Application No: M/7/21/PL
Site Address: 76-78 Elmer Road Middleton-On-Sea PO22 6EX
Description of works: Change the roof & build 1 No. flat above existing flat. This application may affect the setting of a listed building and is in CIL Zone 4 (Zero Rated) as flat.

Thank you for your internet representation made on 15th March 2021 which has been recorded as an objection with the comments as follows:

Proposed Second Floor Plan

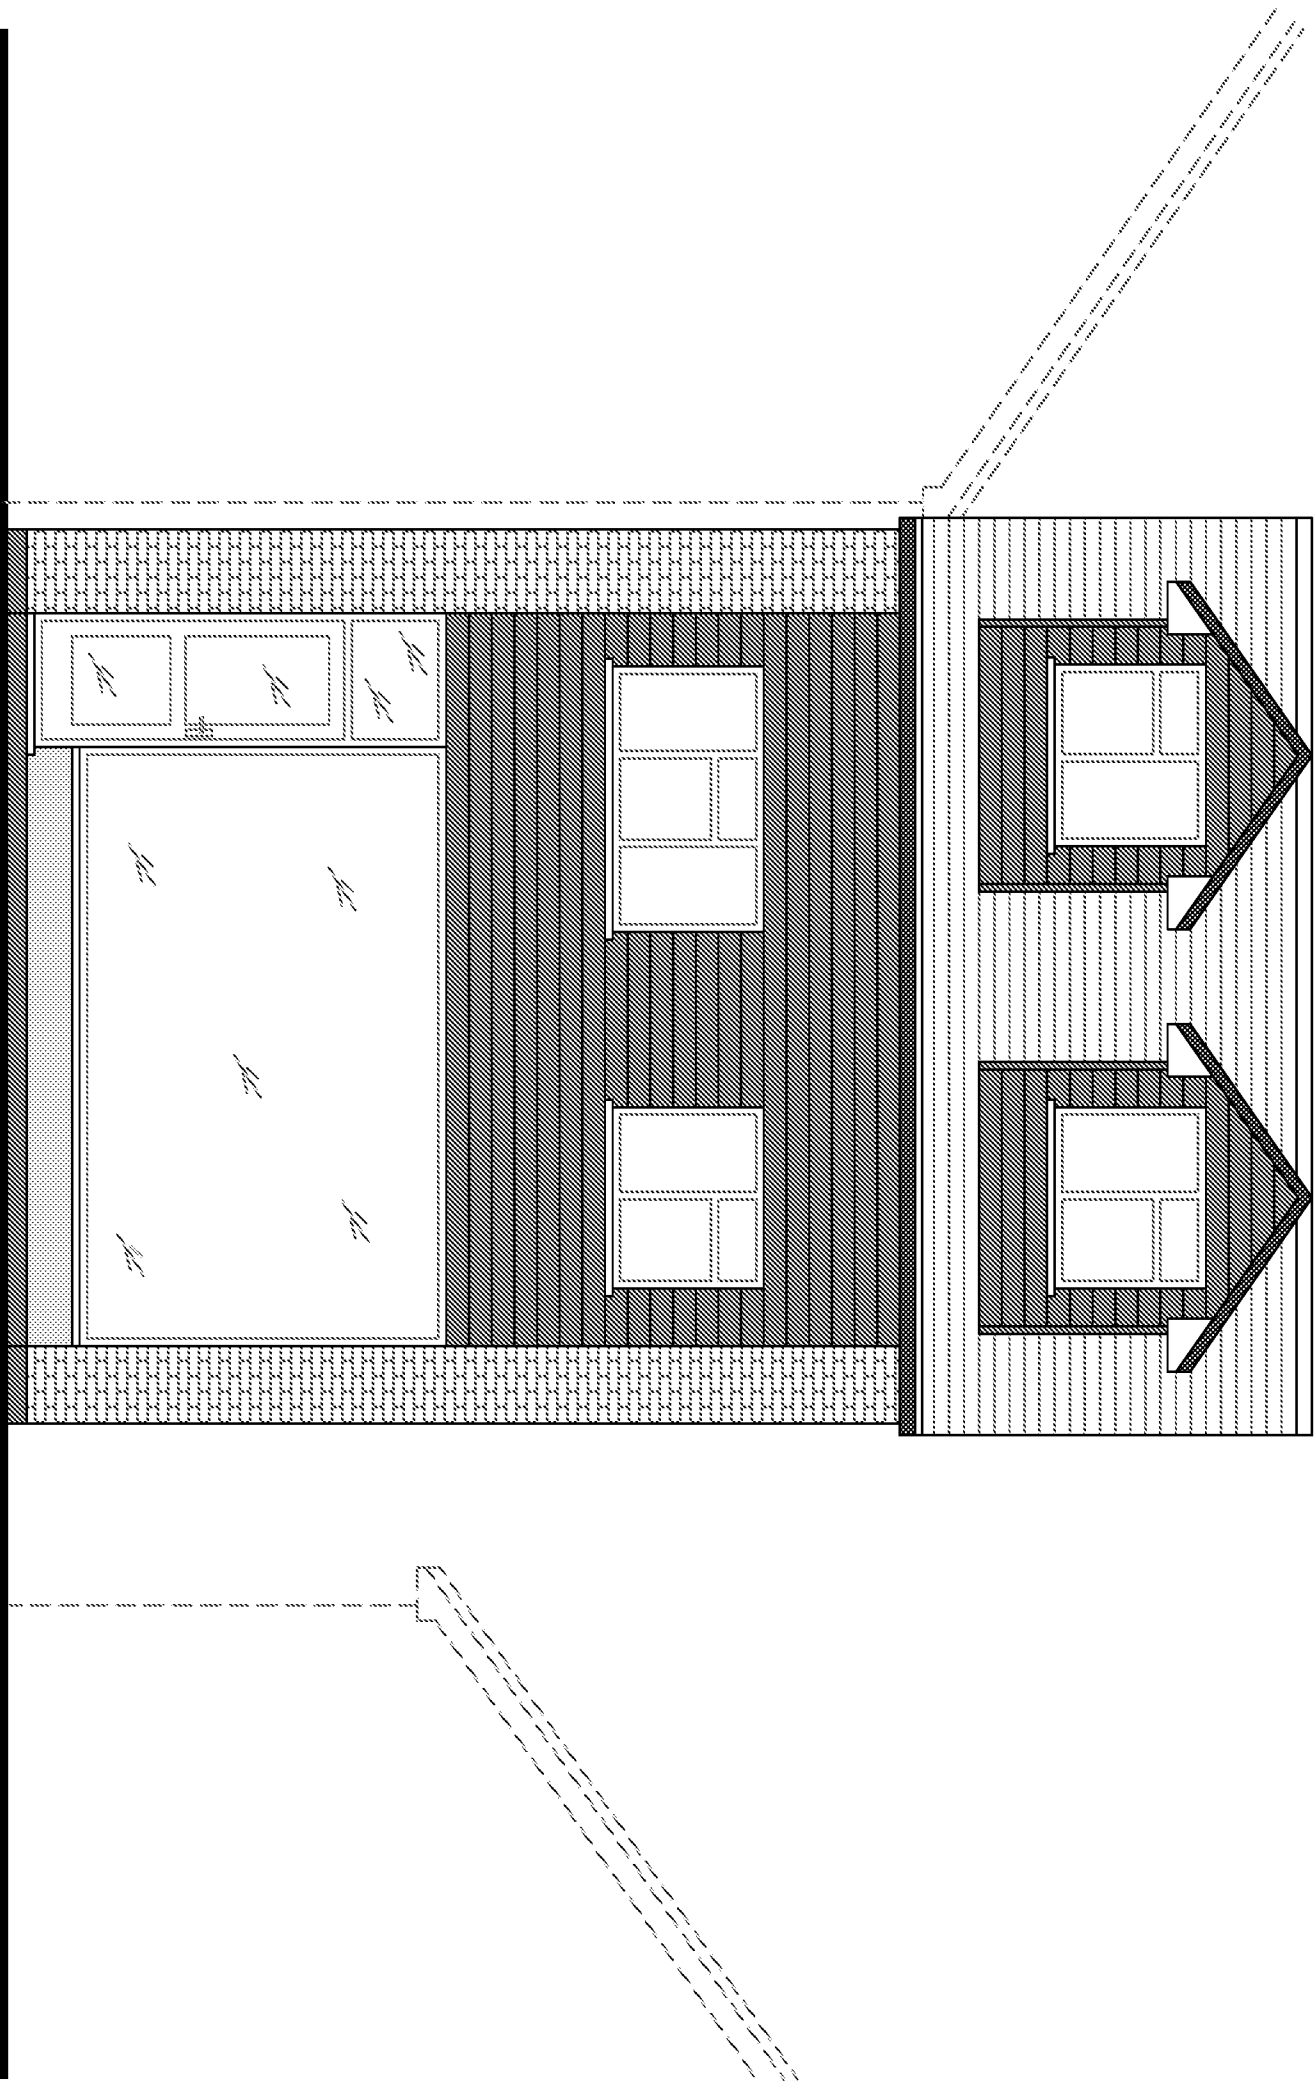
I feel that the building having a 3rd storey will be out of character with neighboring properties.

The 3rd storey extension along with the proposed balconies will be an invasion of privacy on the properties next door and to the back as they will be able to look directly into these properties.
